Agency Submissions

Item	Issue	Response
Department of Planning and Environment		
1	Traffic and parking Provide a copy of the Parking Demand Study and Traffic Assessment (October 2017) referenced in the Traffic Impact Assessment.	The parking study and TIA for the carpark (Oct 2017) is provided at Appendix C .
2	Correct inconsistencies in the number of parking spaces to be removed / provided in the proposed development as set out in the Environmental Impact Statement (366 spaces to be removed and 205 spaces to be provided) and Traffic Impact Assessment (447 spaces to be removed and 201 spaces to be provided).	We confirm the numerics in the EIS are incorrect and the proposal will remove 447 spaces and will introduce 201 car parking spaces as stated in the Traffic Report. It is noted that under separate applications a multi-storey car park and several at-grade car parks are being delivered across the Hospital campus that will increase car park provision (refer to Section 2.2 of the ESI). Inclusive of these non-SSD works, the Hospital will increase parking provision by 834 spaces (Refer to Section 7.3 of the Traffic Report at Appendix H of the EIS).

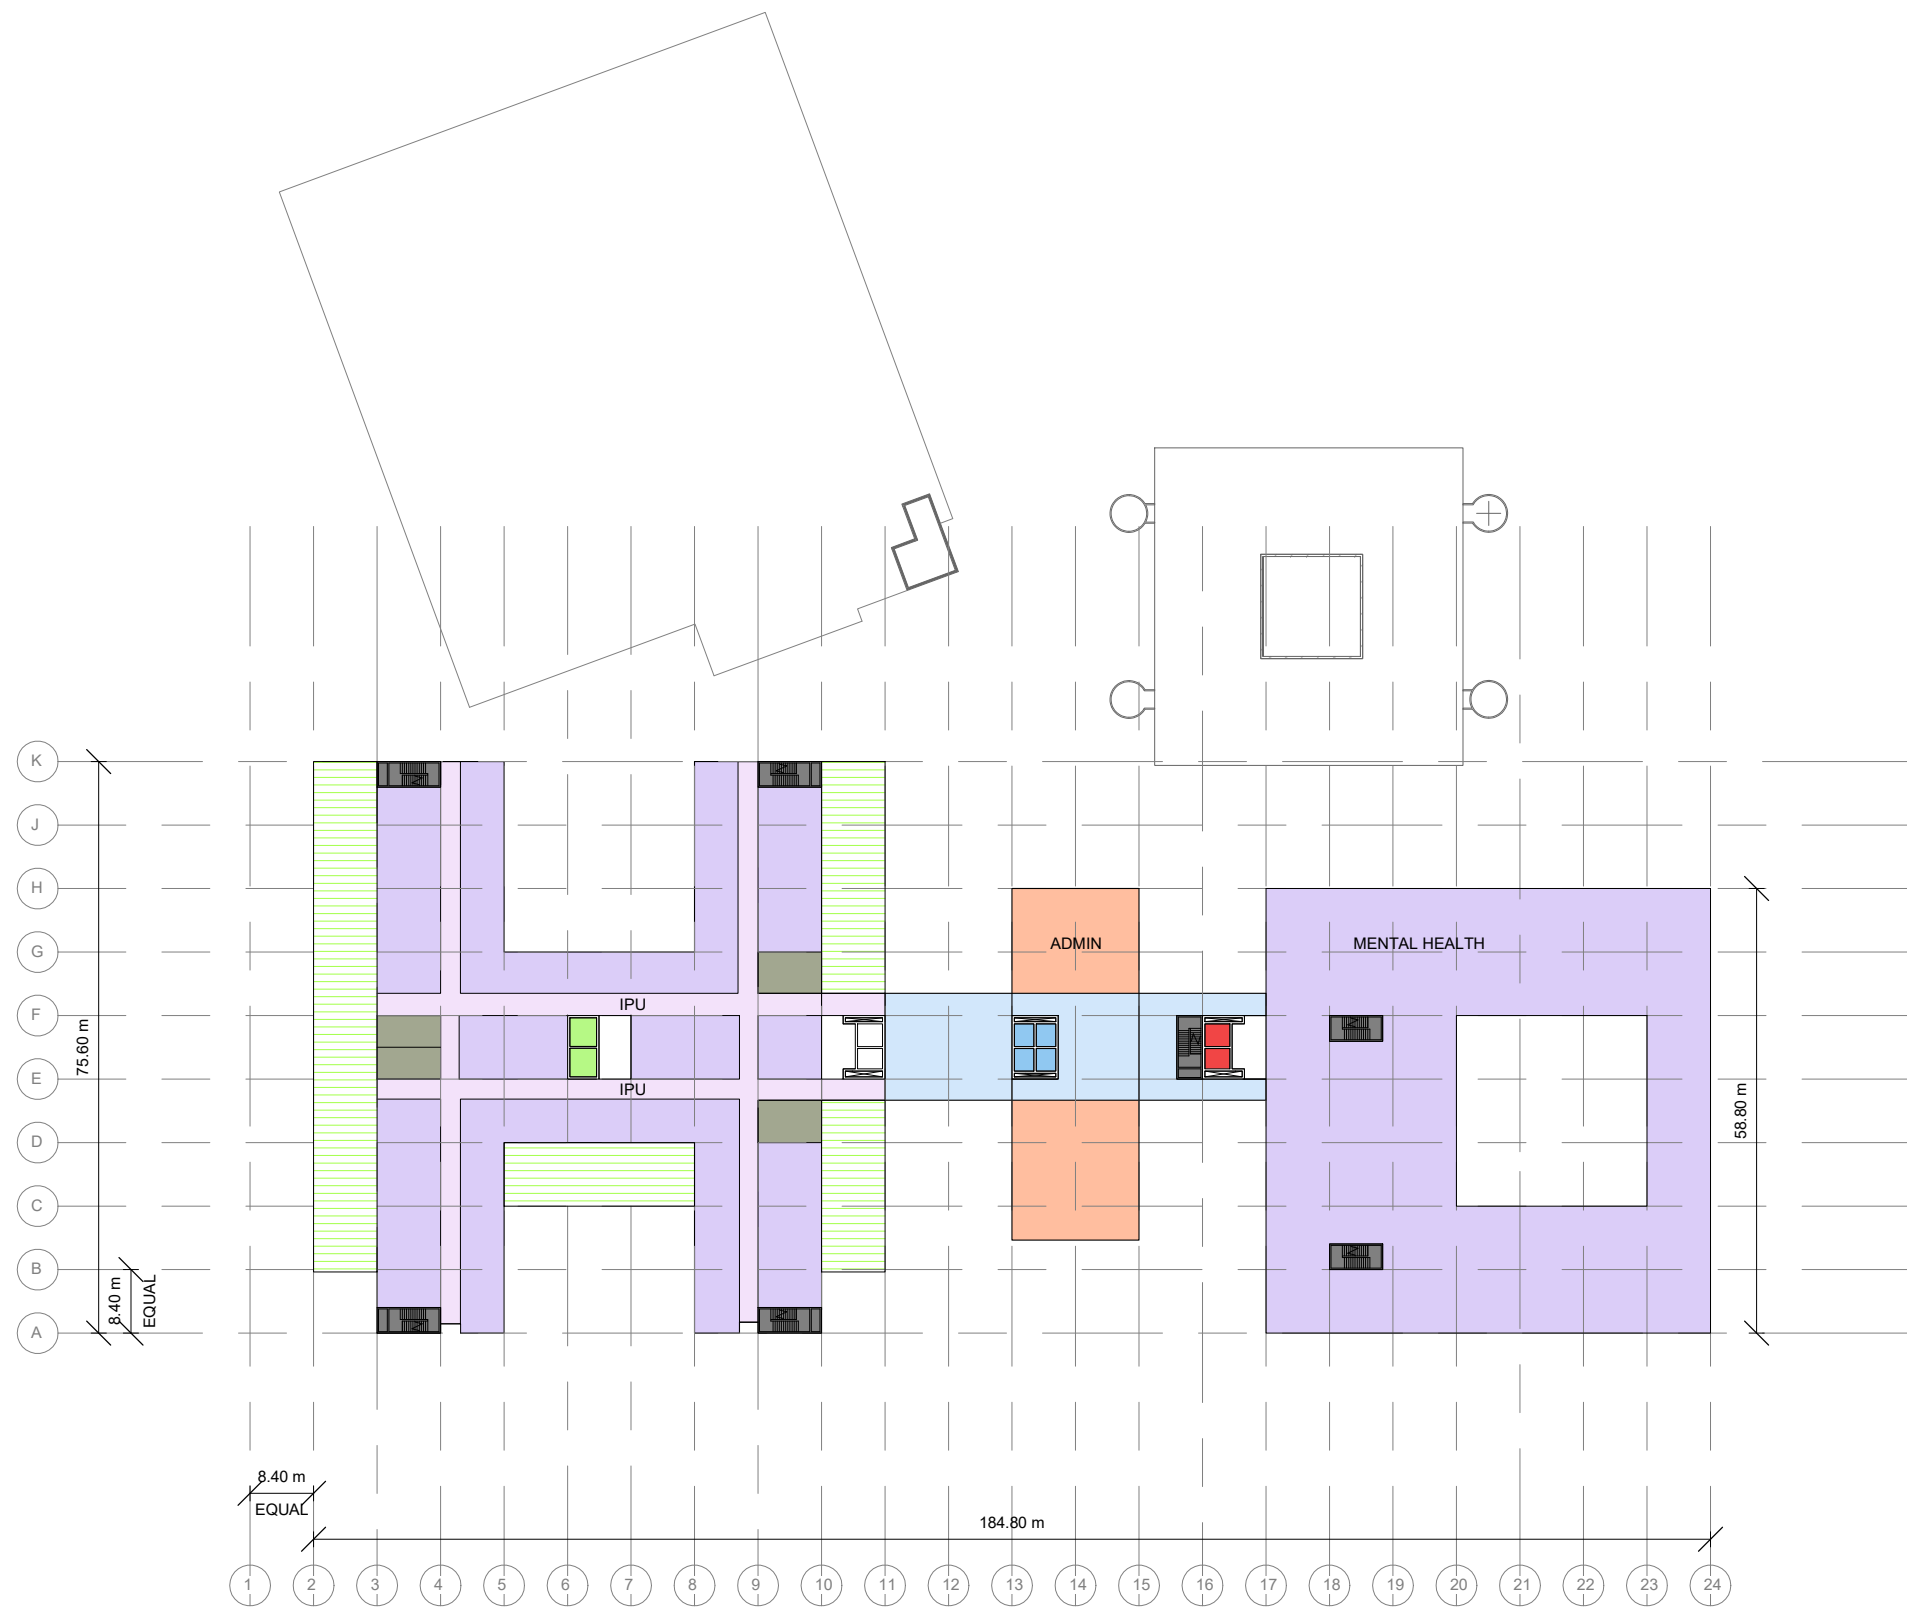
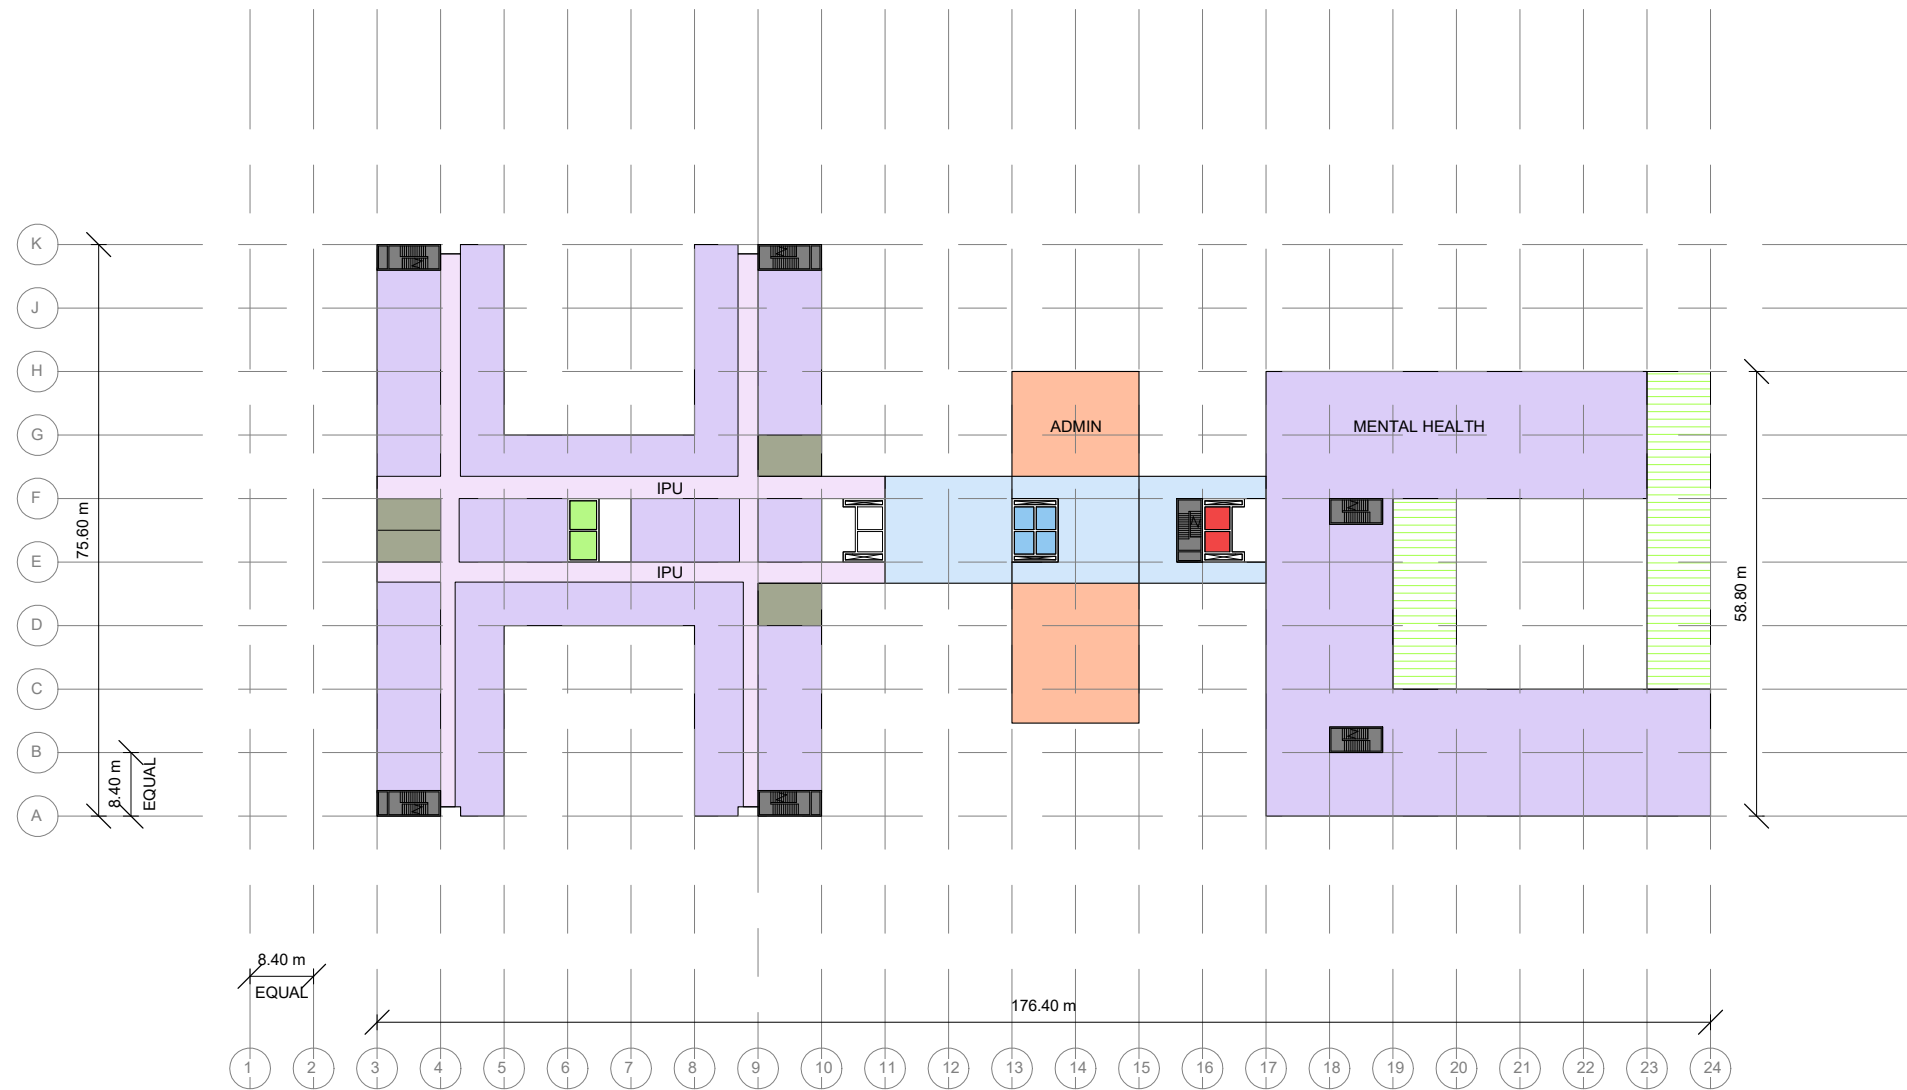
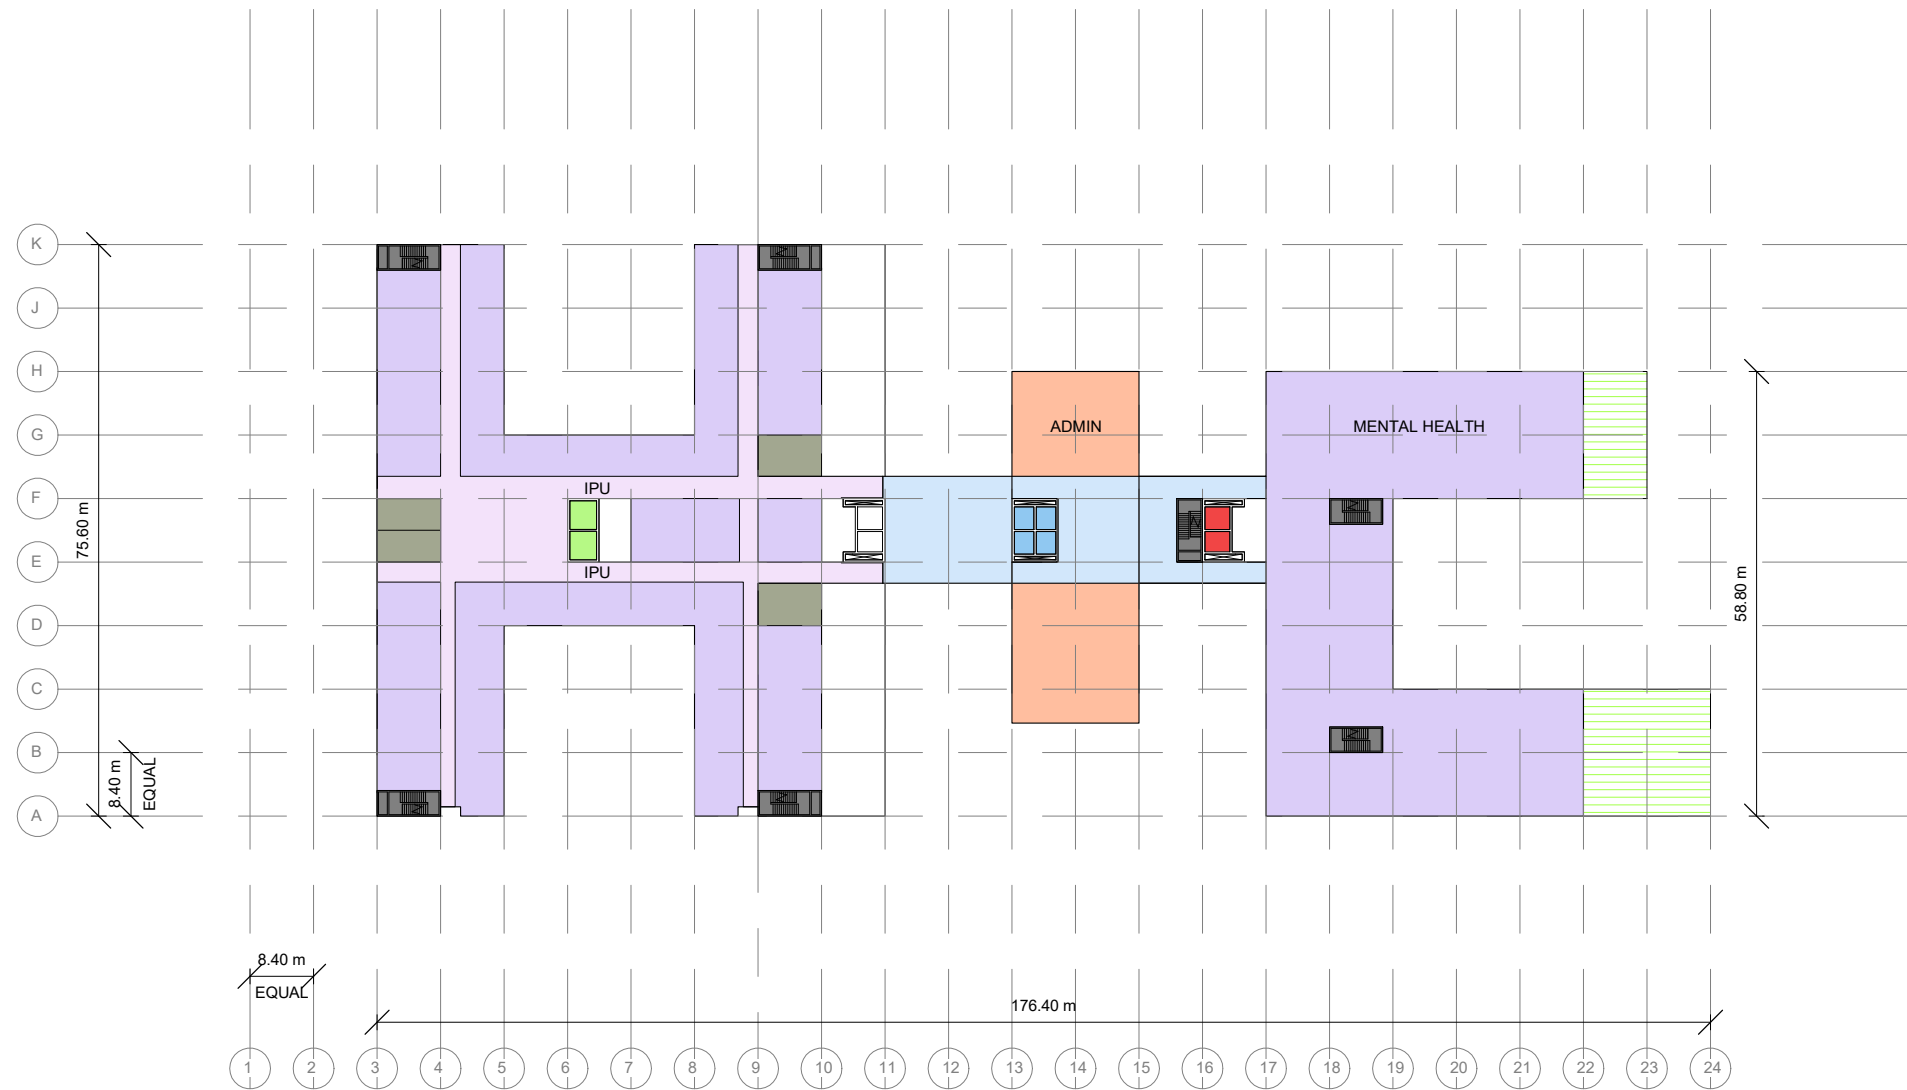
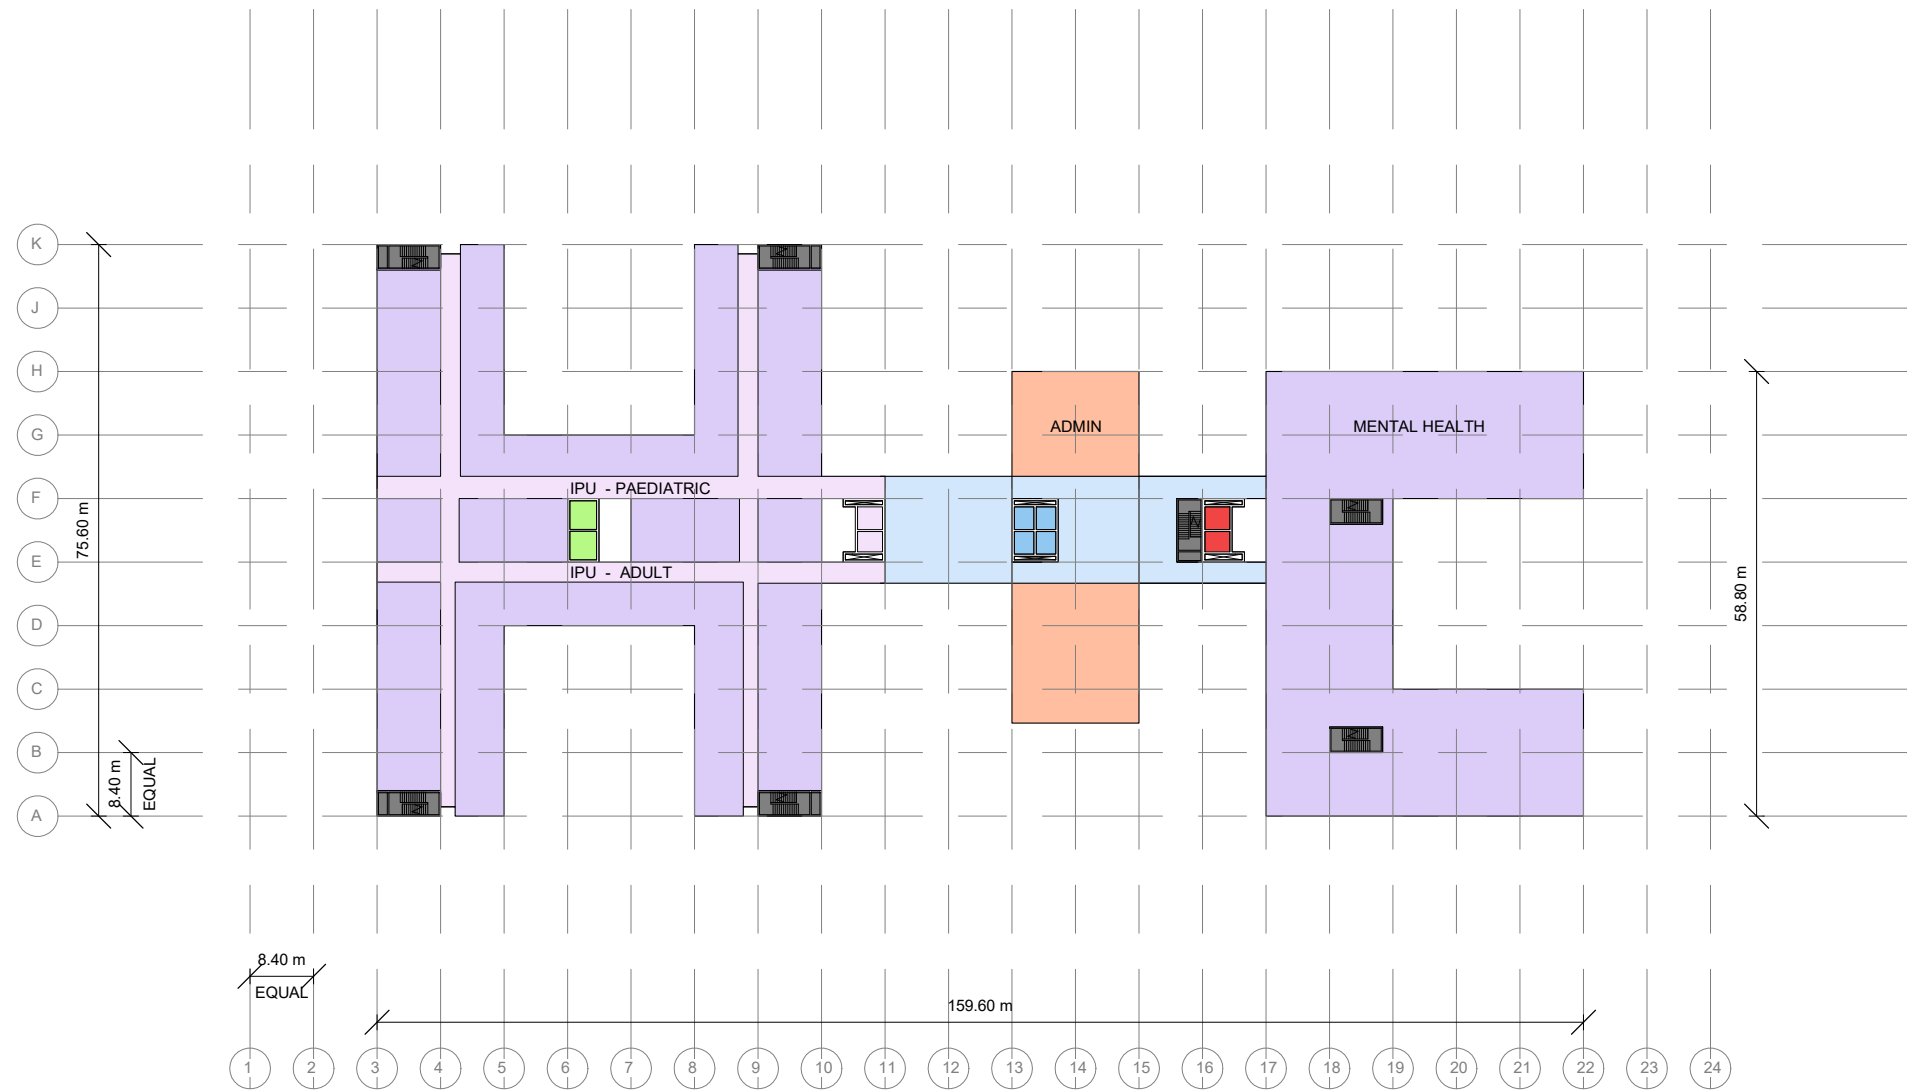
46	<p>Radiation control</p> <p>1. The proponent be required to clarify whether –</p> <ul style="list-style-type: none"> (a) the planned radio-therapy and brachy therapy are included as part of Stage 2; (b) nuclear medicine facilities shown on drawing 'SSD-03-000' are existing or part of Stage 2 refurbishment of building A; (c) diagnostic imaging facilities are to be located in the clinical services building; and (d) diagnostic imaging facilities are to continue to be provided in Building A. <p>2. The proponent be required to ensure shielding of 'regulated material', including diagnostic imaging equipment is assessed and calculated in accordance with the EPA's guidance material provided in "Radiation Guideline 7 - Radiation shielding design assessment and verification requirements".</p>	<p>The following comments address queries 1-3.</p> <p>1.</p> <ul style="list-style-type: none"> a) Yes and additional linac bunker is part of the radiotherapy expansion b) Nuclear medicine facilities are part of the refurbishment of Building A and not part of this SSD application. c) A new satellite imaging department will be located in the Emergency Department of the new CSB. d) The main imaging department will be expanded in its existing location in building A (not part of this application). <p>2. A radiation shielding design consultant has been engaged for the project.</p> <p>3. This comment is noted</p>
